Ref: BR/288/17/PL

RE: 'Rear extension to storage & workshop areas & roof extension at Main Unit Rear of Holmlea Town Cross Avenue Bognor Regis PO21 2DN

I would like to oppose the plans for a roof extension on the works/warehouse building behind 'Merryfield & Holmlea Town Cross Ave'. I am therefore, against the plans and request that you reject them or request a change to them.

Proposed North Elevation

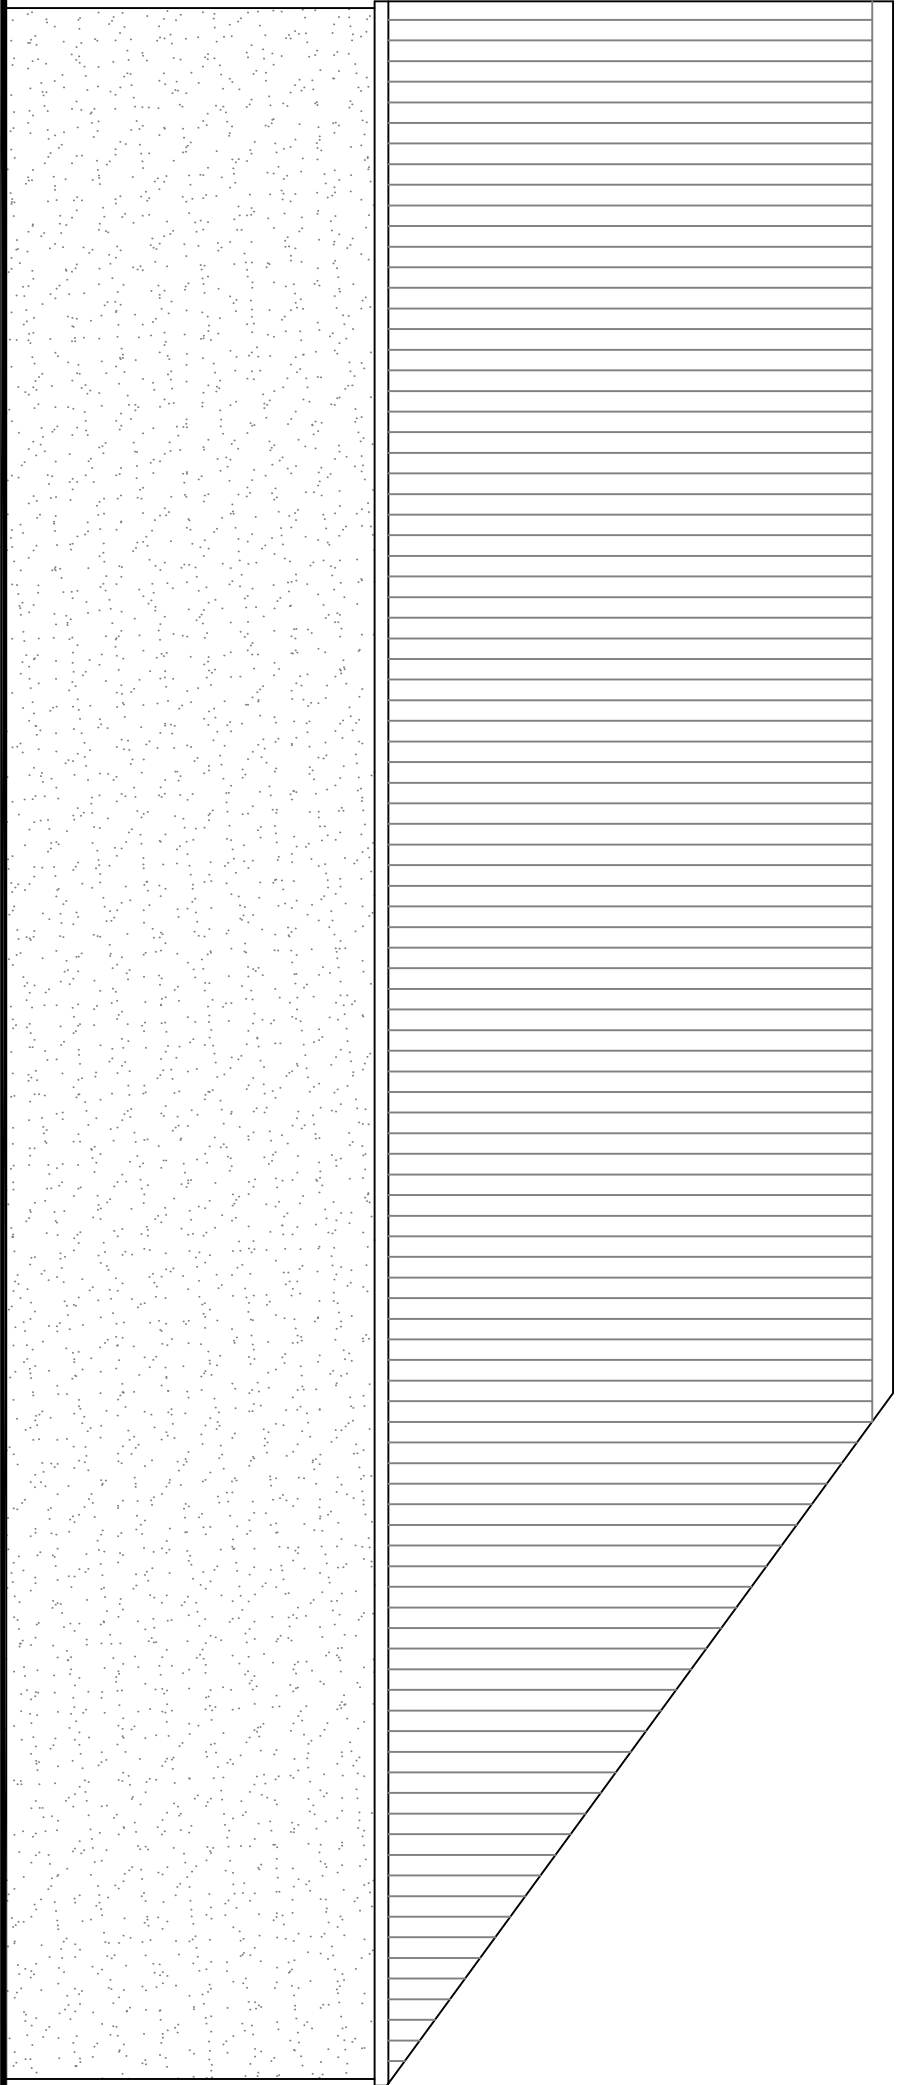
- The proposed building (from the drawings) looks to be much higher than what is currently already there.
- The side of the proposed (1st upper floor 'East') building will be facing the rear my garden 'Merryfield' (with a smaller, ground floor building in front of it) therefore overlooking the rear of my garden with two large windows (the only private part of my garden now due to other houses being built a few years ago, next to my home, four in all).

- The proposed building will also overlook my next door neighbour's garden 'Holmlea'.
- The proposed (1st upper floor 'North') building will be fully looking over the rear of my other neighbour's gardens in 'Essex Road' (5 windows).

- Therefore, the existing buildings are currently only one story high and the proposed (1st upper floor) building will have windows overlooking and removing all our exciting privacy.

- The rear of our gardens will also have reduced daylight due to the proposed building being higher.
